Recommendation Report for Planning Permission for Works or Extension to a Dwelling

REF NO: LU/281/15/HH

LOCATION: 44 Lyminster Road
Littlehampton

PROPOSAL: Vehicular access & crossover with provision of porous parking space within boundary. This application may be determined by Littlehampton Town Council under delegated powers.

Drawing No 15/15/06

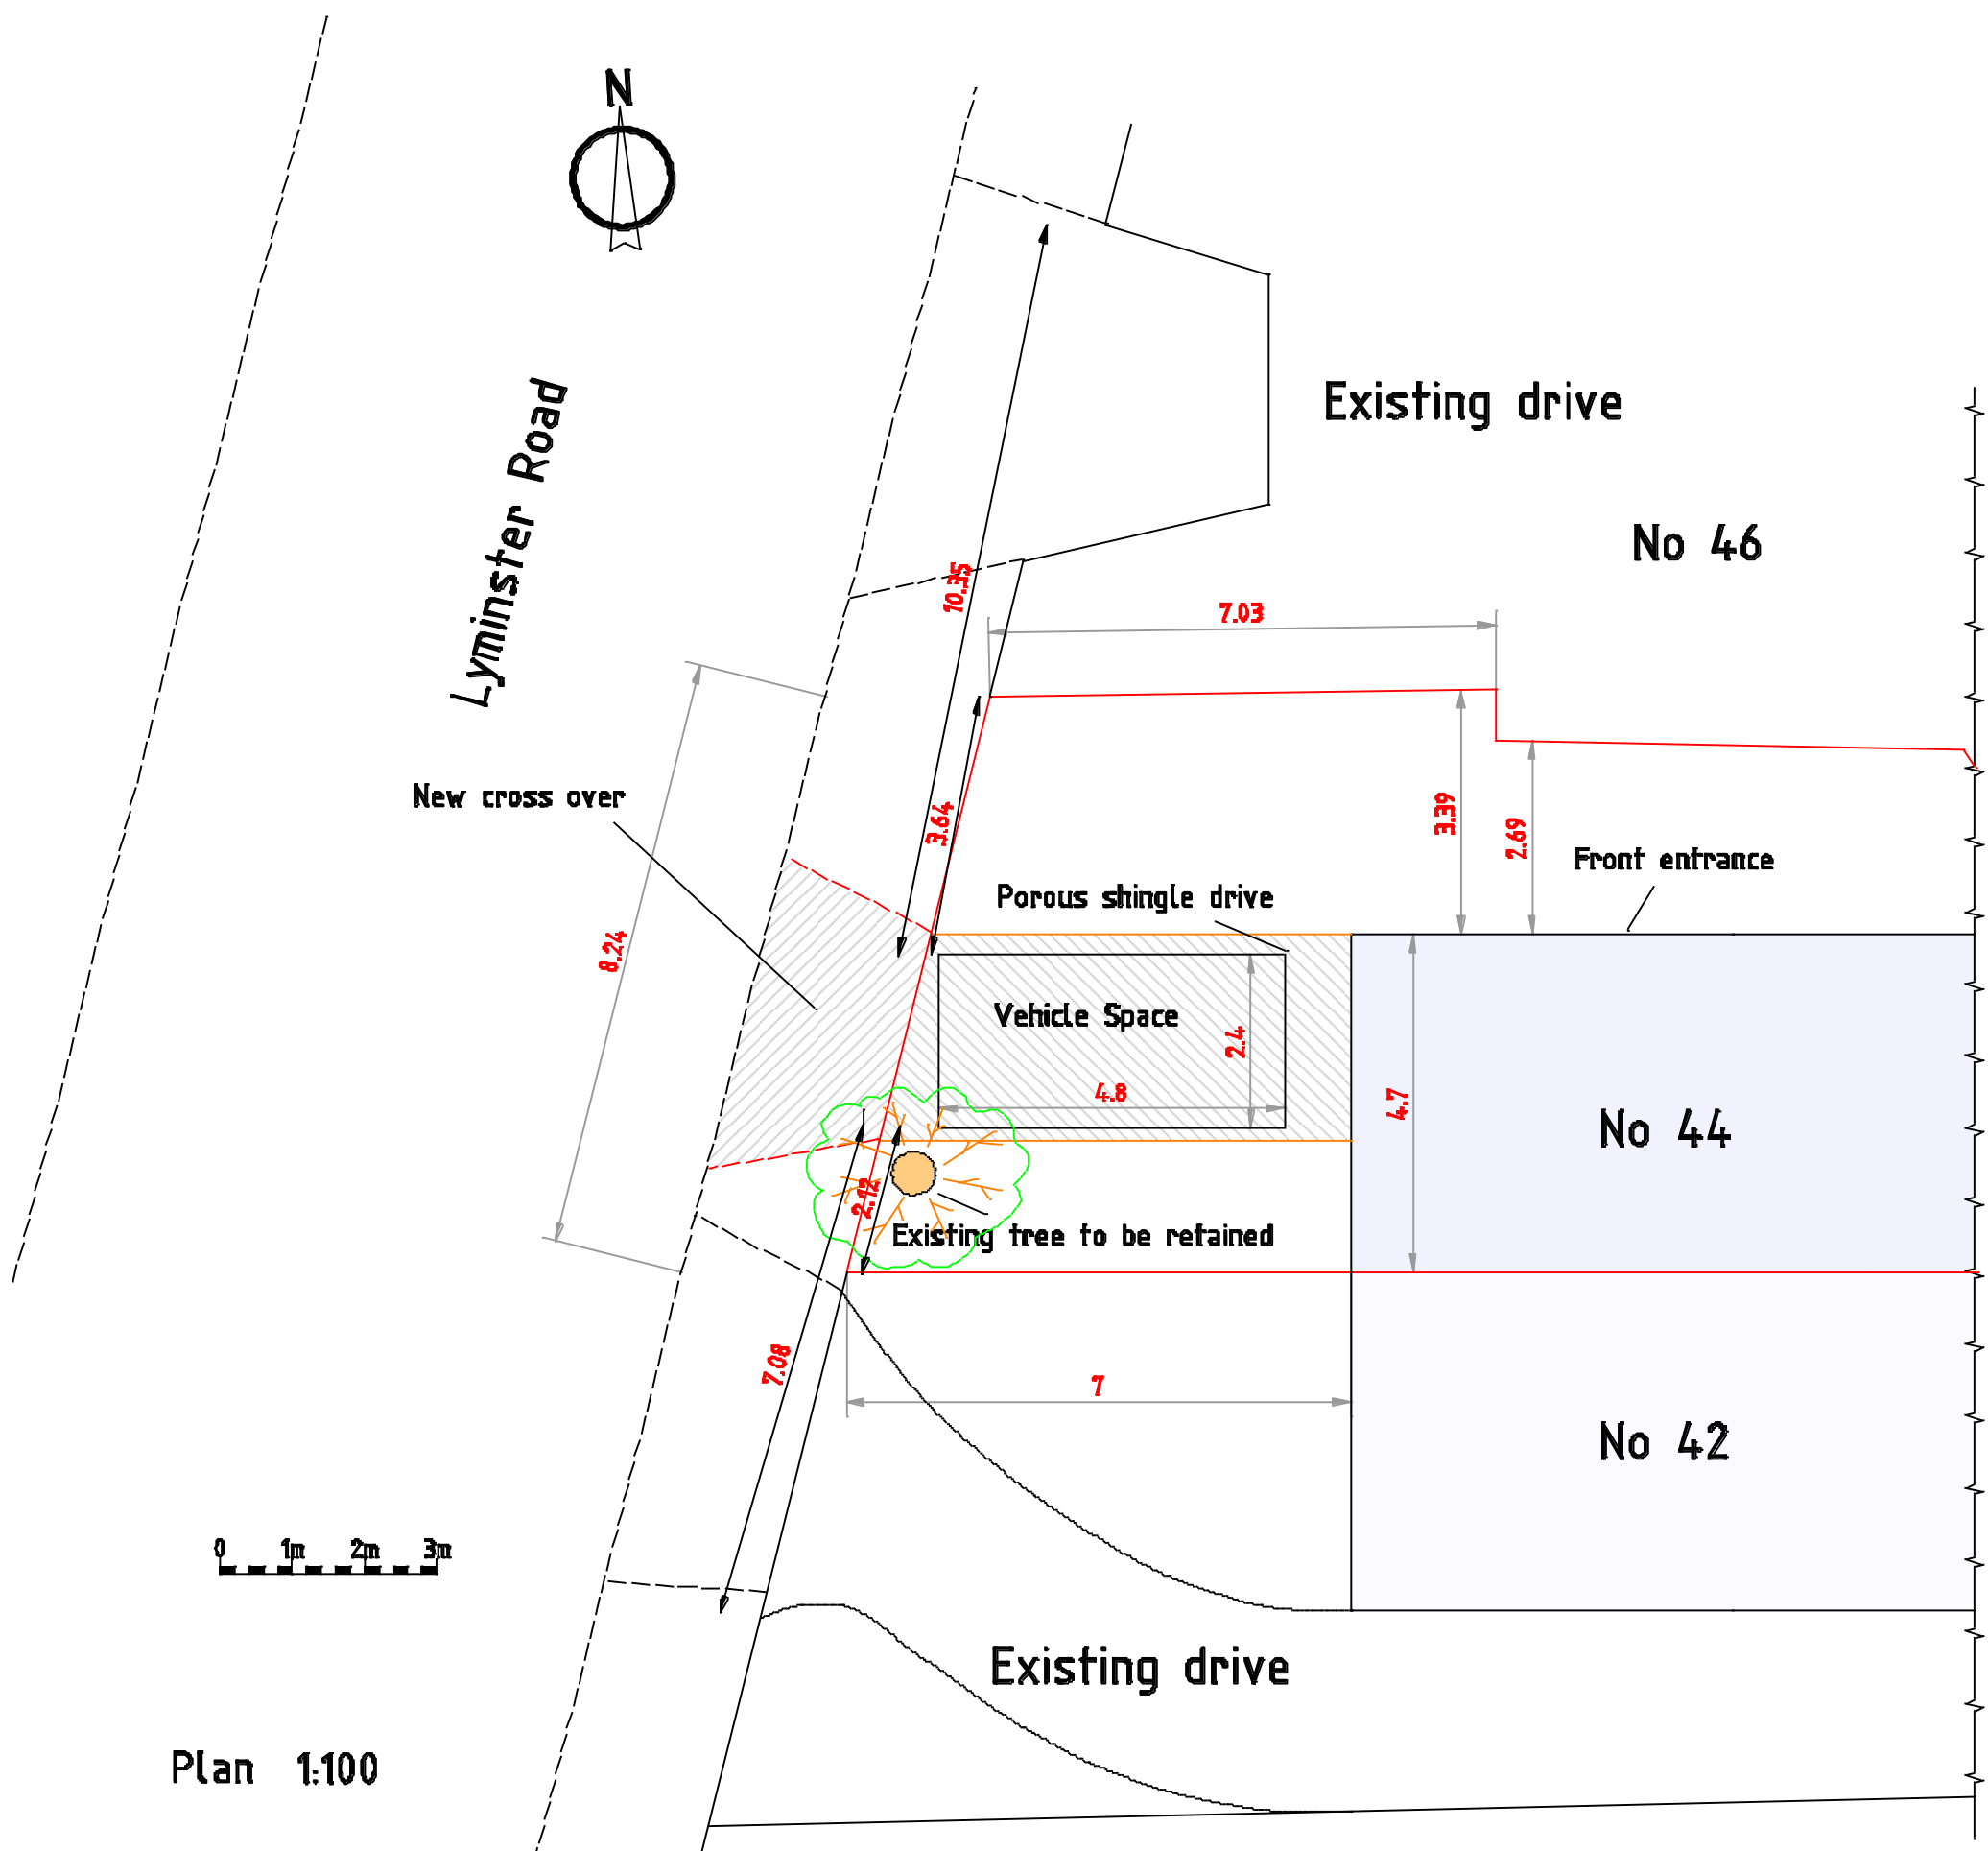
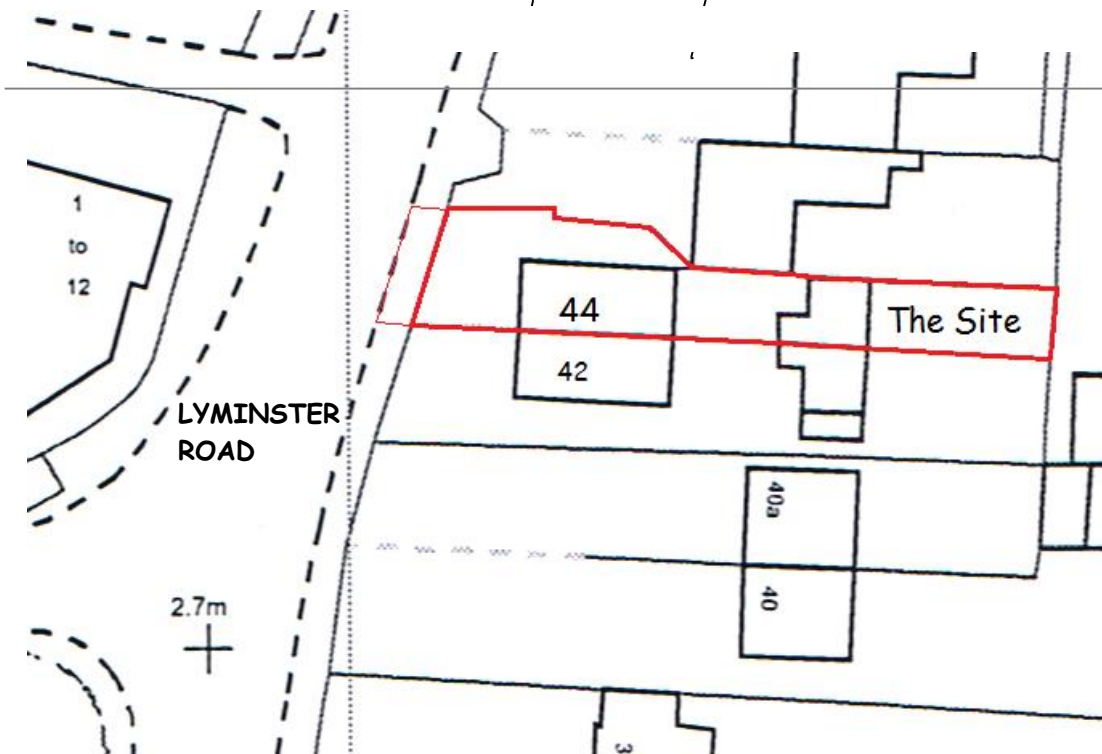
No objection. Neighbouring 42 was subject to a similar dropped kerb where no objections were raised on safety grounds. Recommend, by condition minimum visibility splays and an informative to advise that consent of highway authority is also required for the access.

- 4 The hard surface hereby approved shall be construction from a porous material, or provision shall be made to direct run-off water from the hard surface to a permeable or porous area or surface within the curtilage of the dwellinghouse.
